CITY OF PORTLAND, MAINE
HISTORIC PRESERVATION COMMITTEE

061-C-008

July 26, 1999

Re: Front Porch Replacement

Guard 2 1/2'
Single Panel

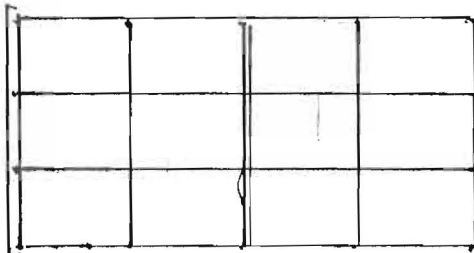
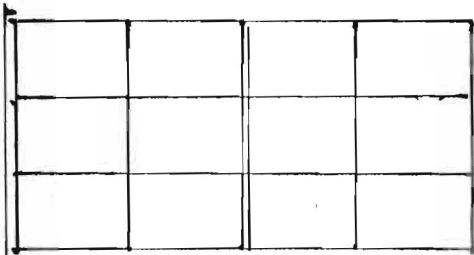
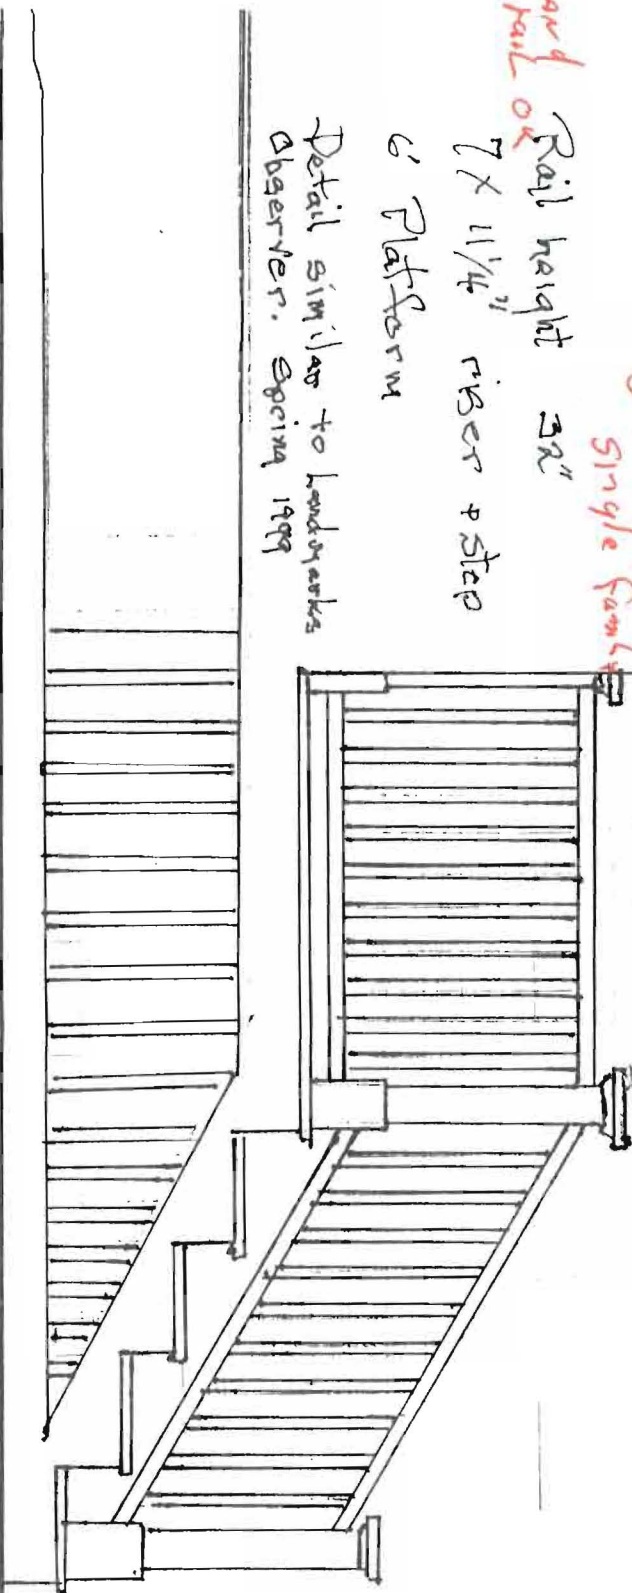
- * That porch posts measure 5" x 5".
- * That a scotia molding be installed under post caps and stair treads
- * That balusters measure 1 1/2" x 1 1/2" (actual) and be spaced 4" on center.
- * That a vertical trim board be installed underneath the mid post. The width of the vertical board shall be at least as wide as the corresponding post
- * That the skirtboard measure 7 1/4"

Note: The Committee also approved a turned post top as an alternate to the post top shown in the application materials.
